PEDESTRIAN WIND ENVIRONMENT STATEMENT

16-20 MIDDLE HARBOUR ROAD, LINDFIELD

WJ864-01F02(REV1)- WS REPORT

PTI ARCHITECTURE (SYDNEY) PTY LTD

DRAWING TITLE:  
**LOWER GROUND FLOOR PLAN**

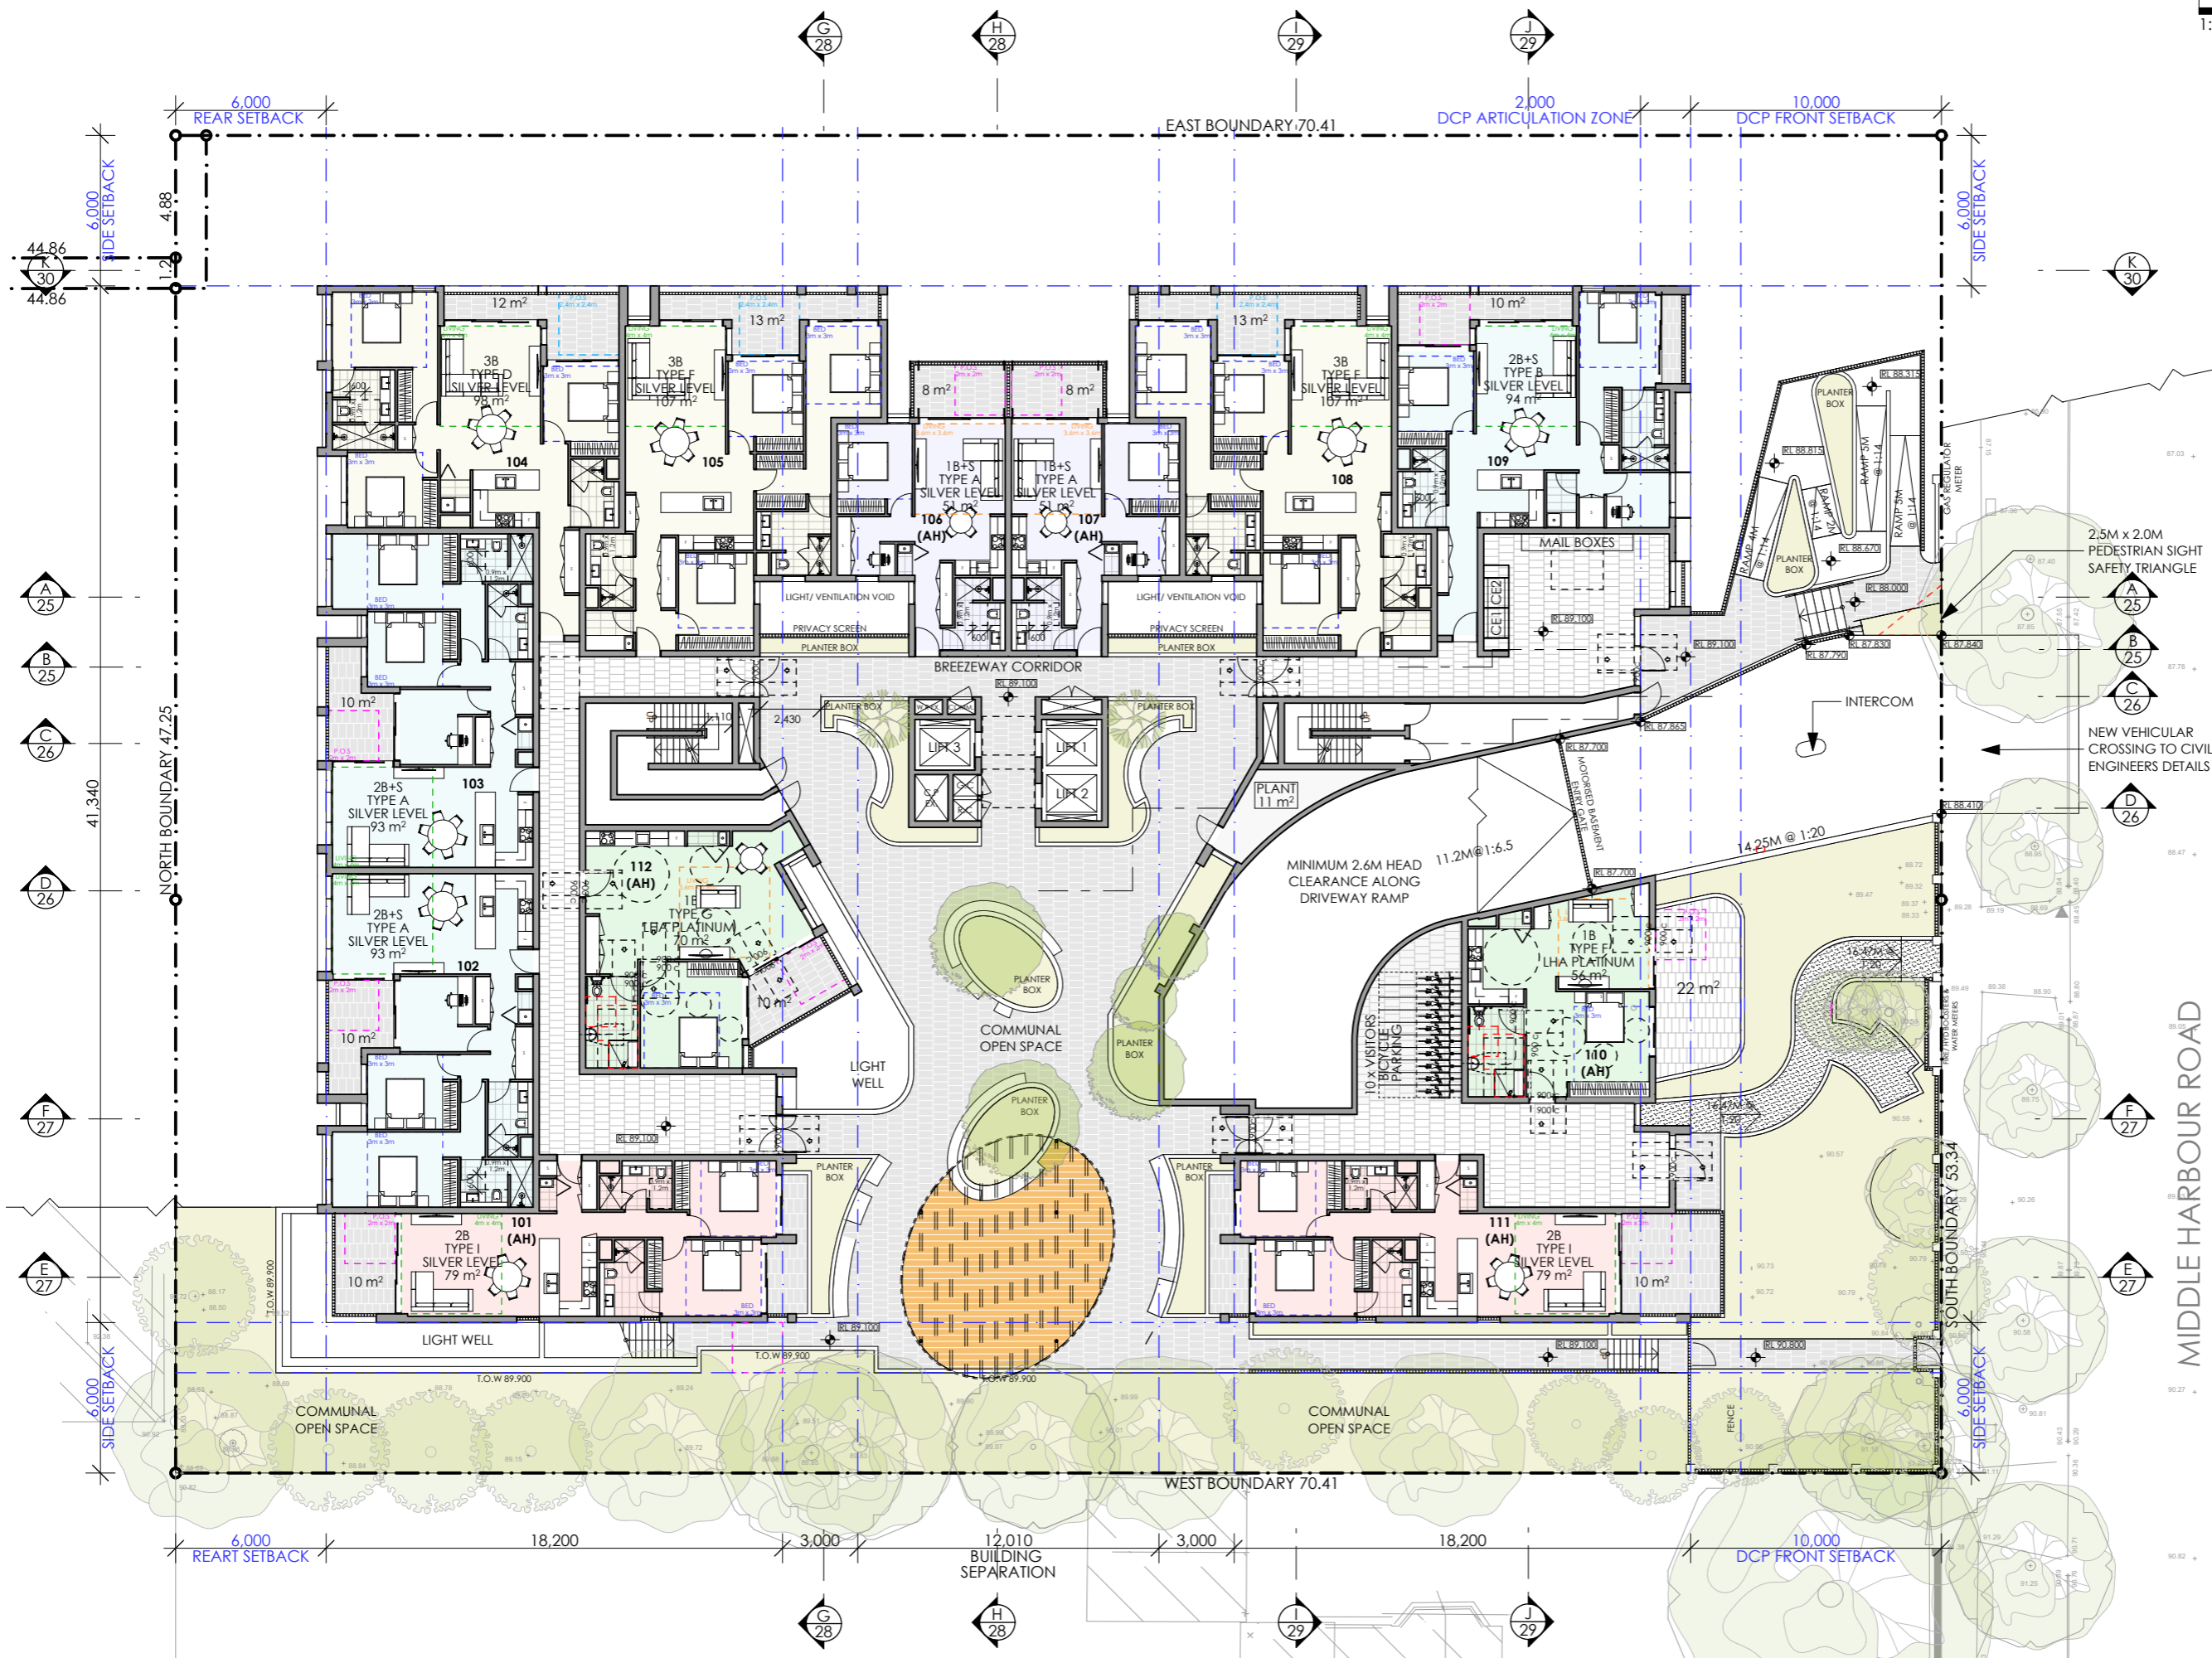
The existing buildings and densely foliating evergreen trees located to the east and north of the site are expected to partially shield the proposed Ground Level areas from the prevailing north-easterly and westerly direct winds. Direct winds are however expected to impact the northern, eastern and southern Ground Level areas. These prevailing winds, as well as the southerly winds can impact the corresponding facades and downwash onto the ground plane, which can deteriorate the wind conditions within the areas immediately adjacent to the façade. These wind effects can be ameliorated via awnings, impermeable screens and vegetation.

- Inclusion of impermeable awnings to the south and north, abutting the eastern aspect of the building envelope.
- Increasing the height of the proposed impermeable intertenancy screen along the northern perimeter of the south-eastern corner private balcony to 2m above the FFL.
- Retention of the proposed full-height porous screening along the southern aspect, adjacent to the car park entrance.

- Converting the proposed inter-tenancy screen to the north (between the two east most apartments on the northern aspect) to a full-height impermeable screen.
- Inclusion of 2m high evergreen and densely foliating hedges/shrubs within the proposed planter boxes along the eastern perimeter of the site.

DRAWING TITLE:  
**UPPER GROUND / LEVEL 1  
FLOOR PLAN**

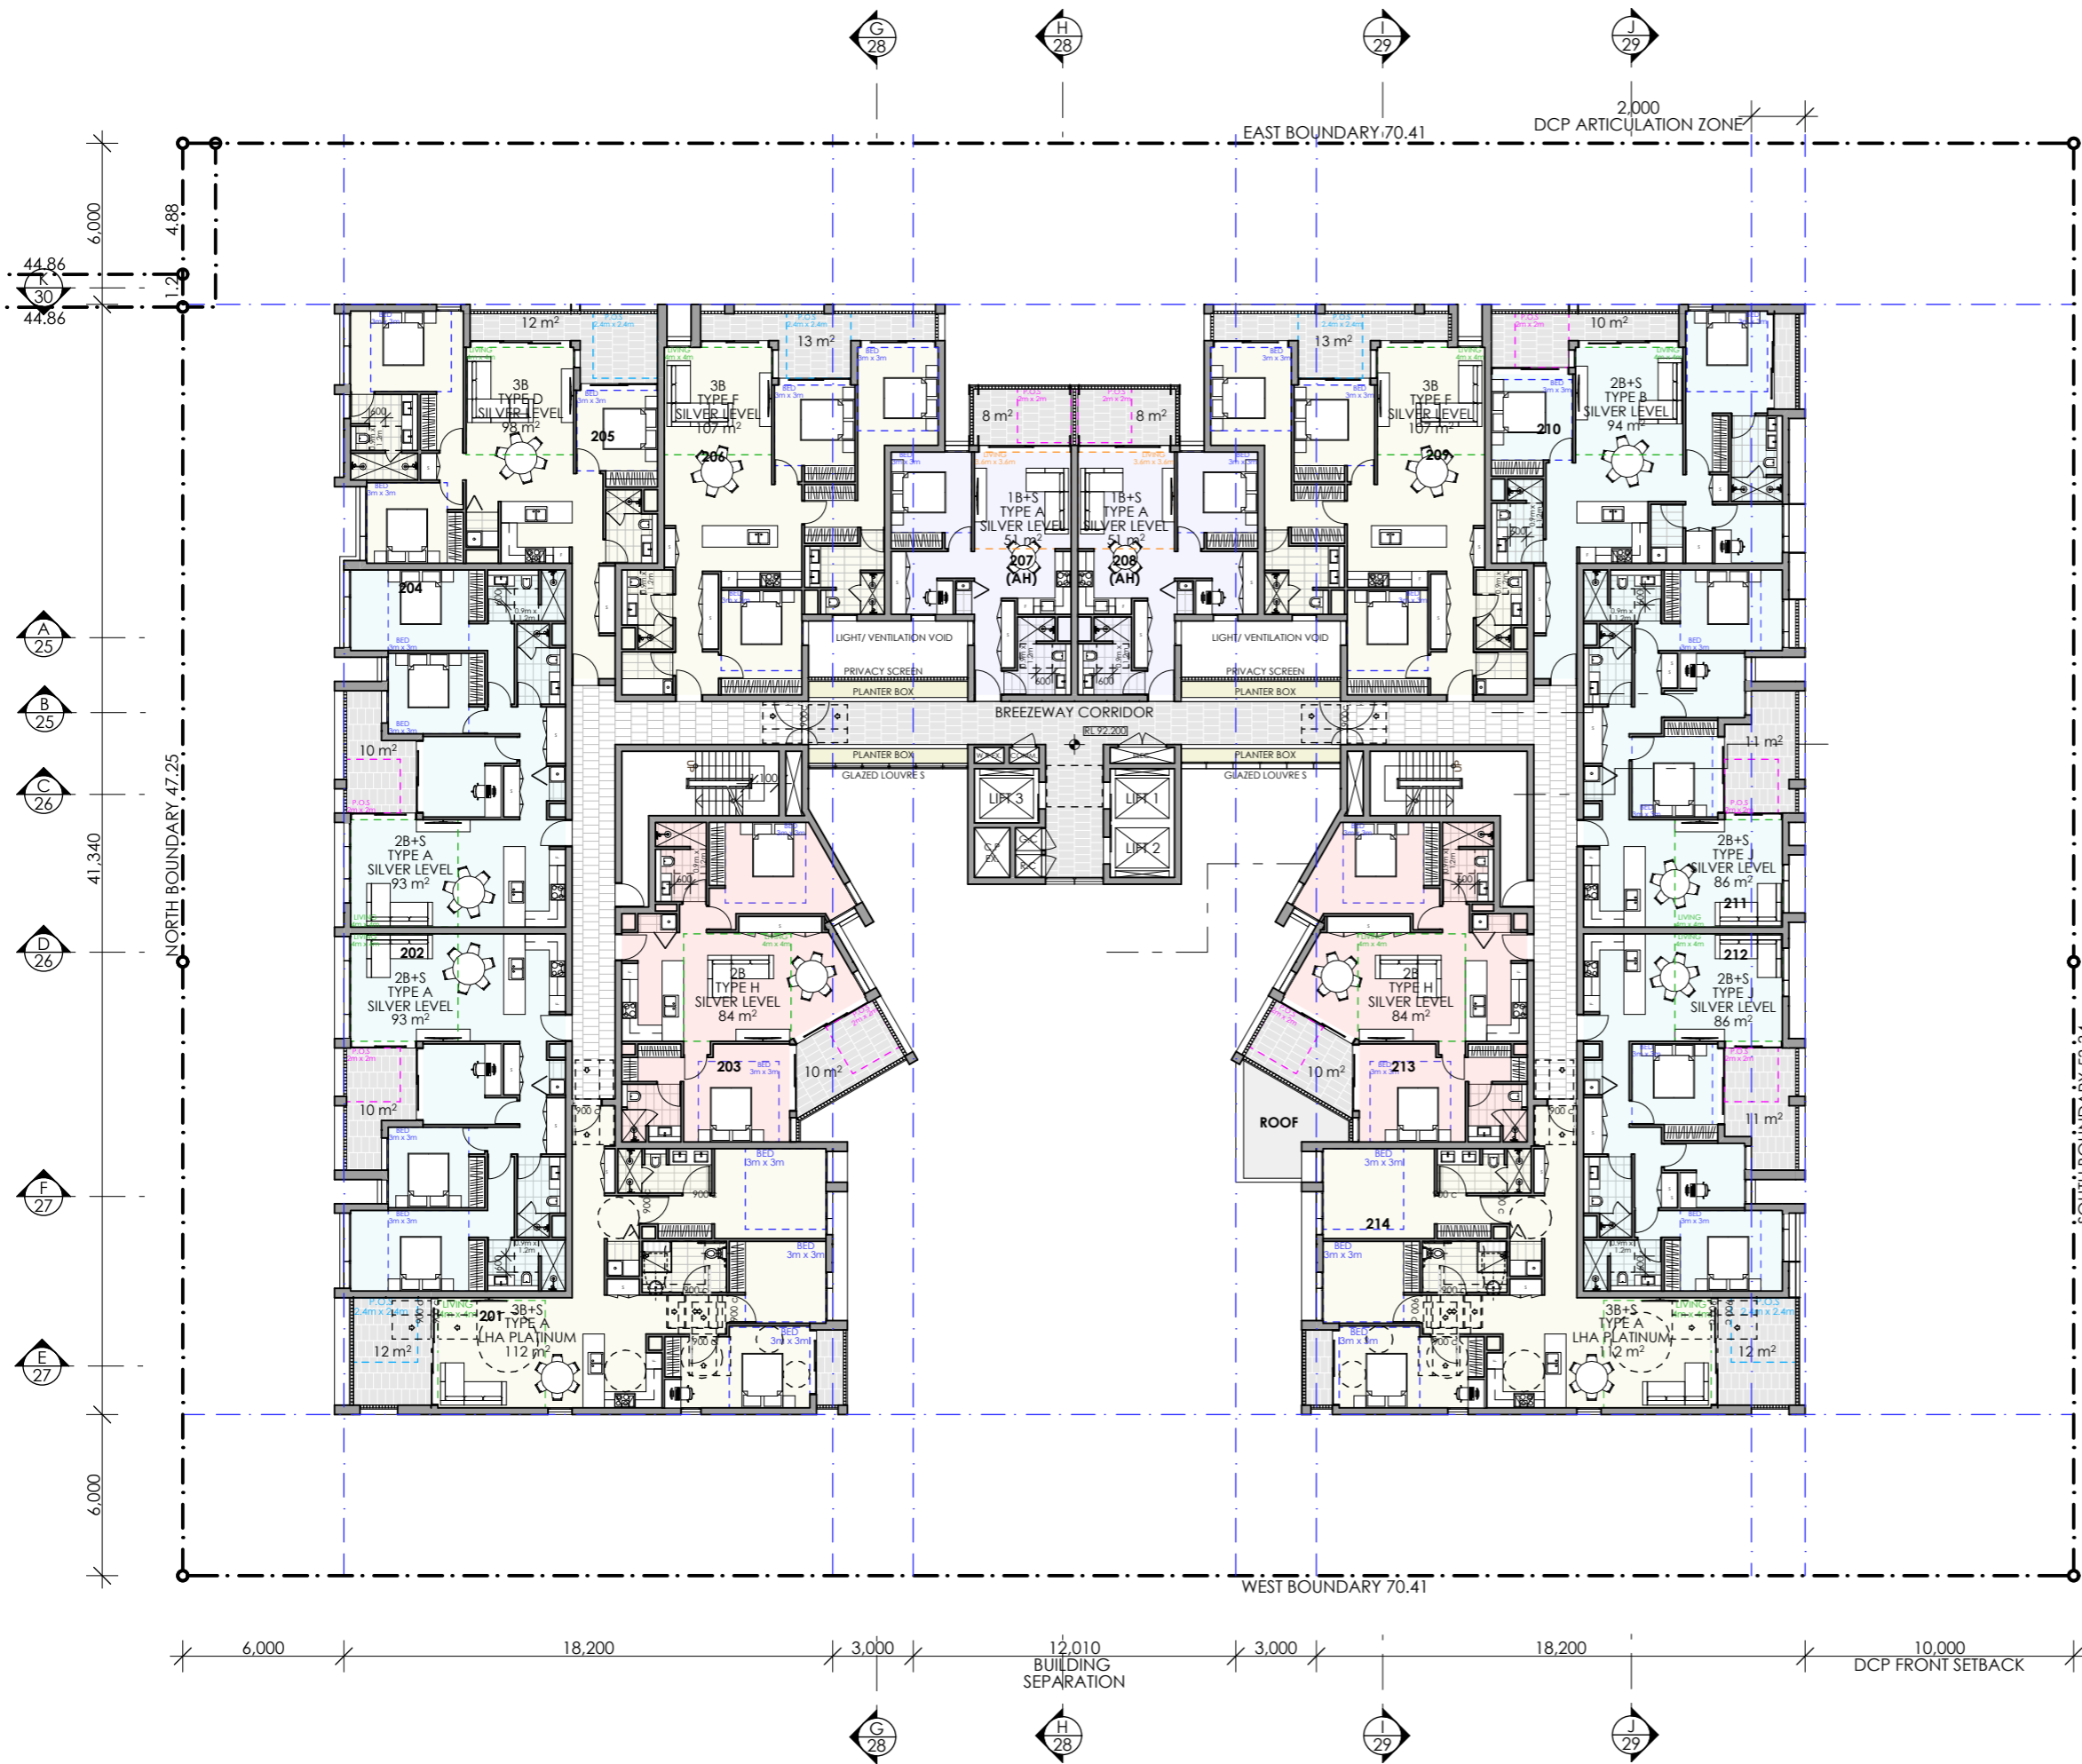
The Upper Ground Level areas are exposed to the prevailing southerly, westerly and north-easterly winds. Amongst these, the westerly and the southerly winds will travel through the west facing building separation (i.e. the communal open space), which will likely deteriorate the wind conditions for building patrons. The north-easterly winds will travel along the southern façade, however, given the alignment of these winds with the southern façade, the wind conditions in the vicinity are expected to be comparable to the existing conditions. Furthermore, the northern and western corner balconies are exposed to corner acceleration effects due to the prevailing westerly and southerly winds, respectively. These wind effects can be ameliorated via impermeable screens and strategic inclusion of vegetation.

- Inclusion of 2m high evergreen and densely foliating hedges/shrubs within the proposed planter boxes through the building separation zone.
- Inclusion 3-5m high and 3-5m wide (i.e. 3-5m wide canopies) evergreen and densely foliating trees along the central strip within the building separation zone as well as to the west of the site (communal open space).
- Inclusion of full-height impermeable screens along the shorter aspects of the northern and eastern corner balconies.
